**DETERMINATION OF MAJOR PROJECT NO. 08-0064**

**ADDITIONS TO THE MUSEUM OF CONTEMPORARY ART**

**140 GEORGE STREET, THE ROCKS**

### RECOMMENDED CONDITIONS OF APPROVAL

EAST ELEVATION

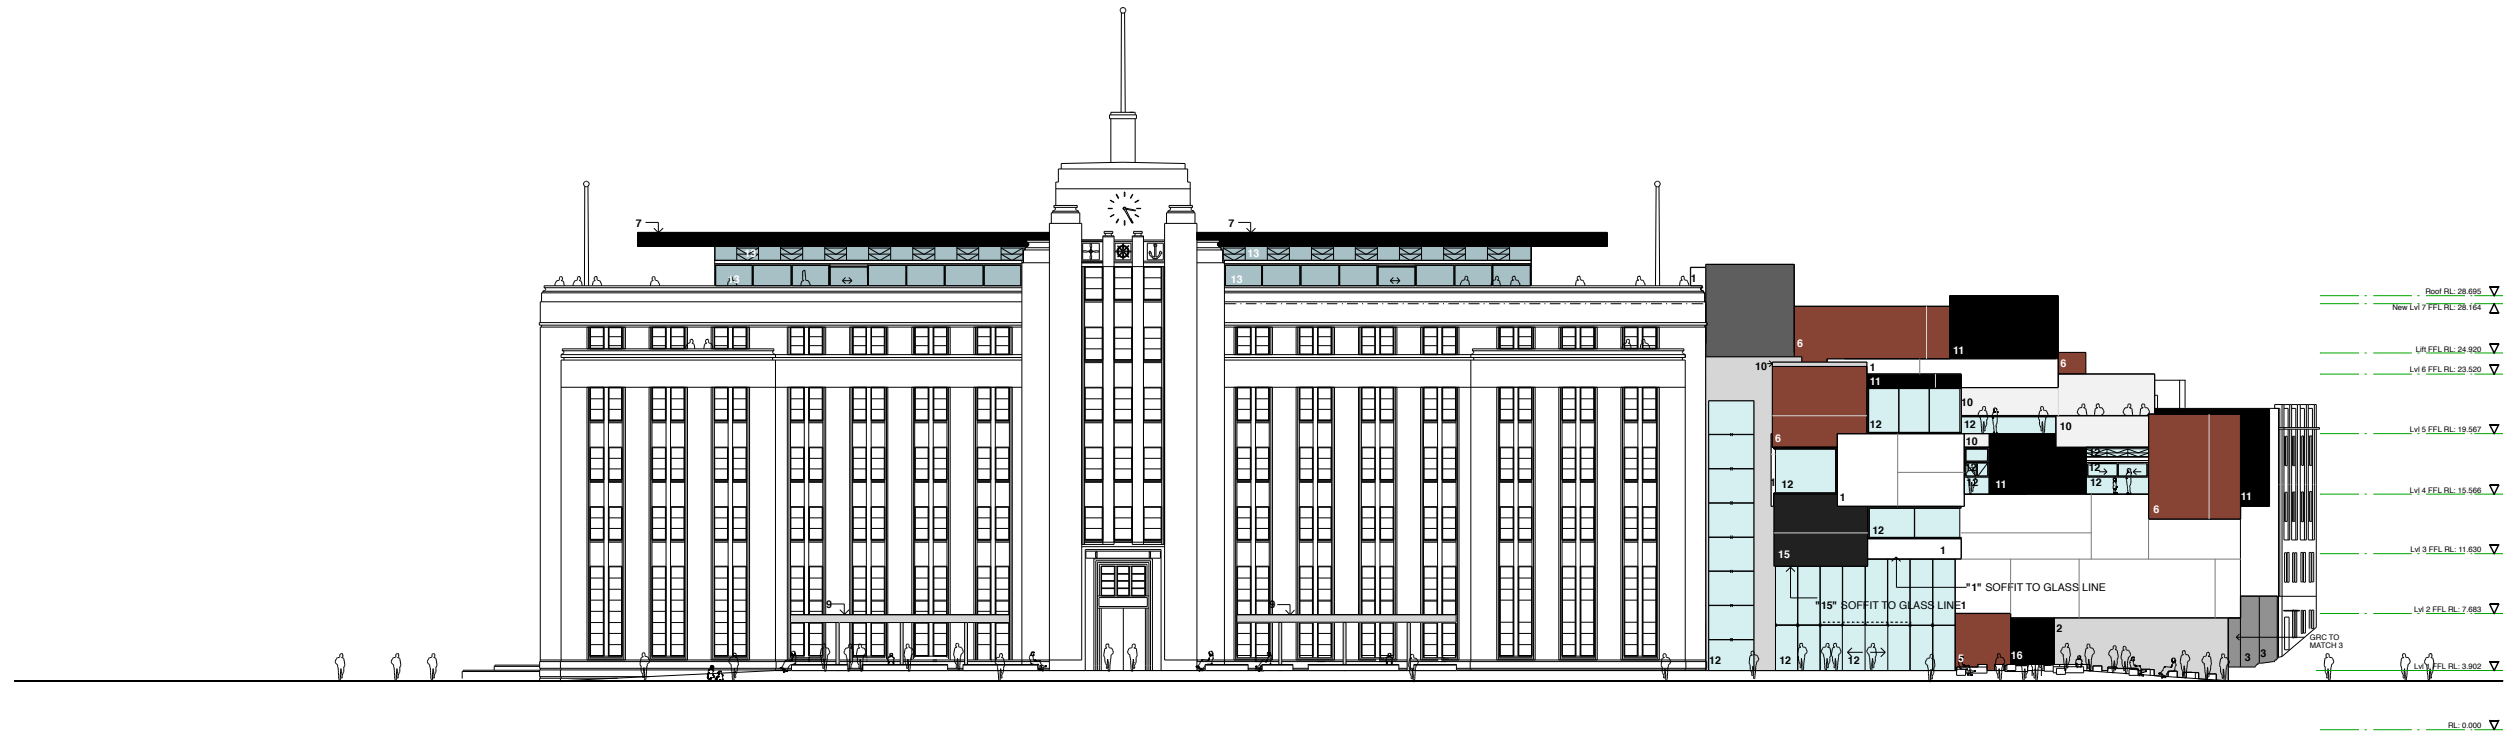
- (c) The materials to the western façade of the George Street elevation of Level 7 are to be clad in coloured backlit glass;
- (3) The thickness of awning edges to the Level 1 terraces fronting Circular Quay are to be reduced from approximately 470mm to 300mm; and
- (4) The final location, orientation and aesthetic treatment of the proposed fire boosters to George Street are to be determined with regard to minimising any physical obstruction or visual intrusion into the streetscape at pedestrian level, and these matters are to be developed in consultation with the SHFA and NSW Fire Brigade.

WEST ELEVATION

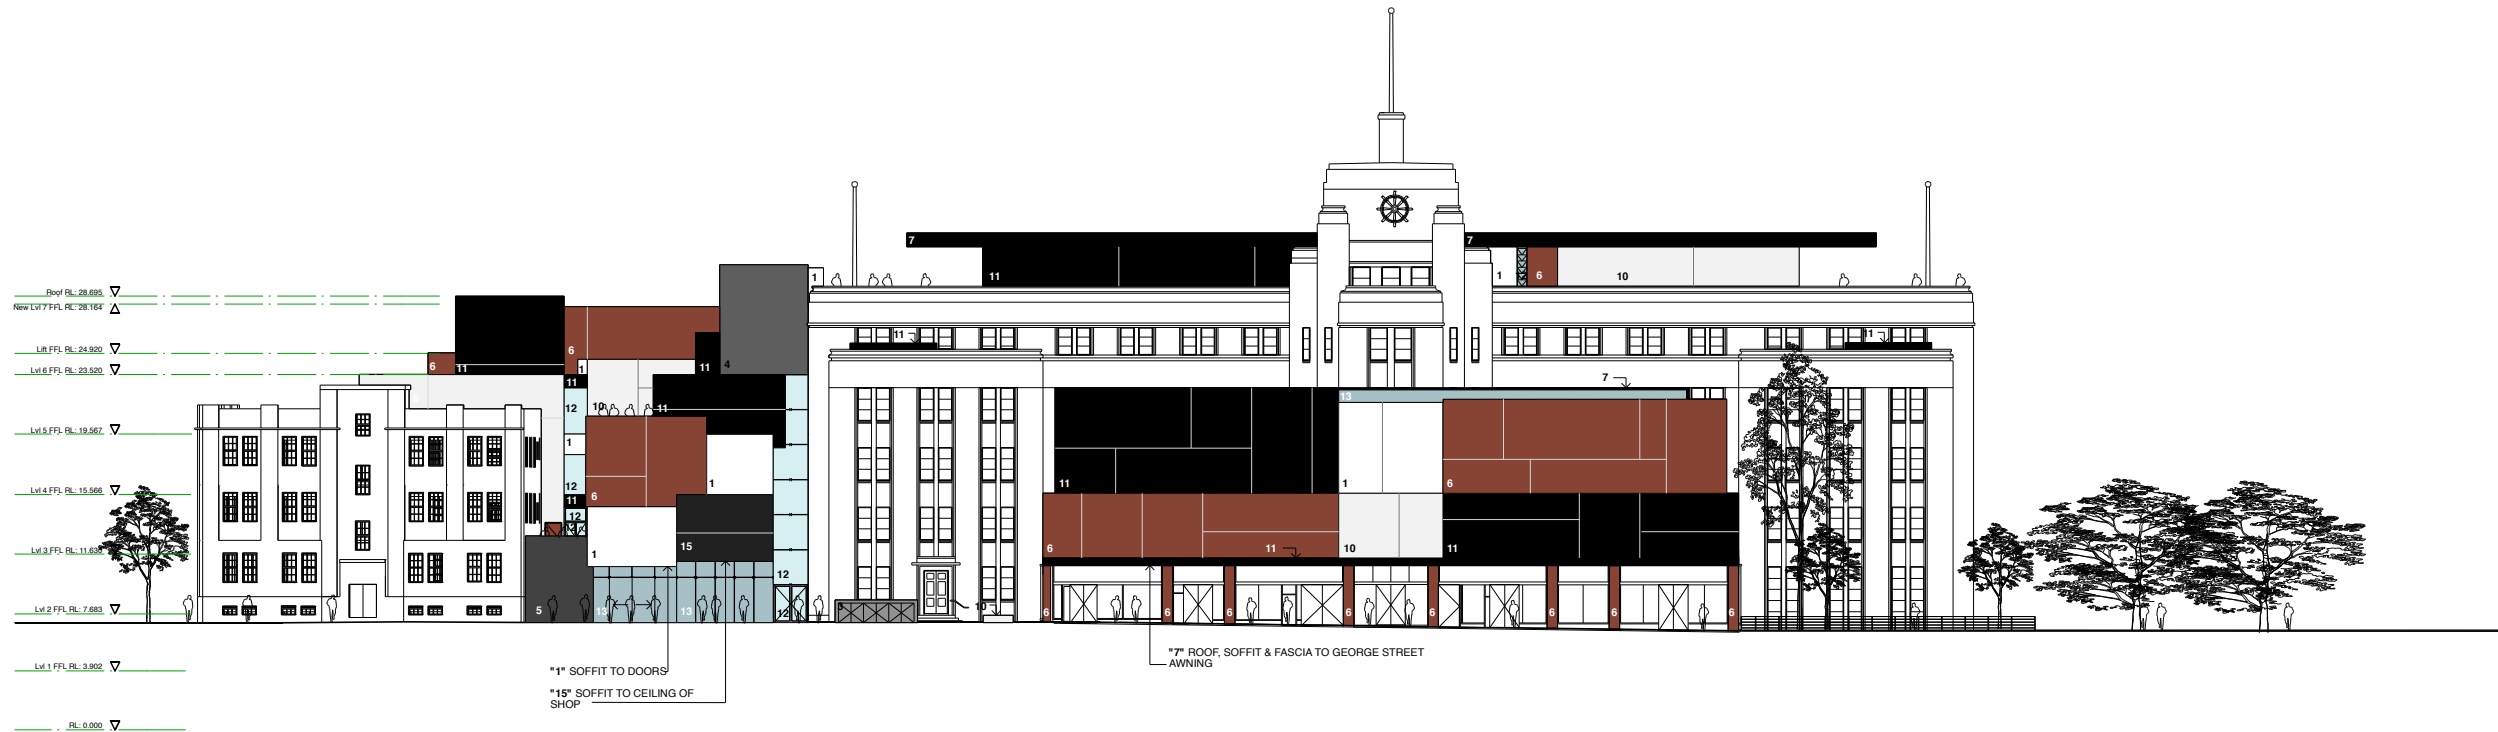
- (2) Level 7 addition
  - (a) The colours of the roof structure and awning detail to Level 7 above the existing MCA building are to be of light, recessive and non-reflective tones, such as silver, grey and white.
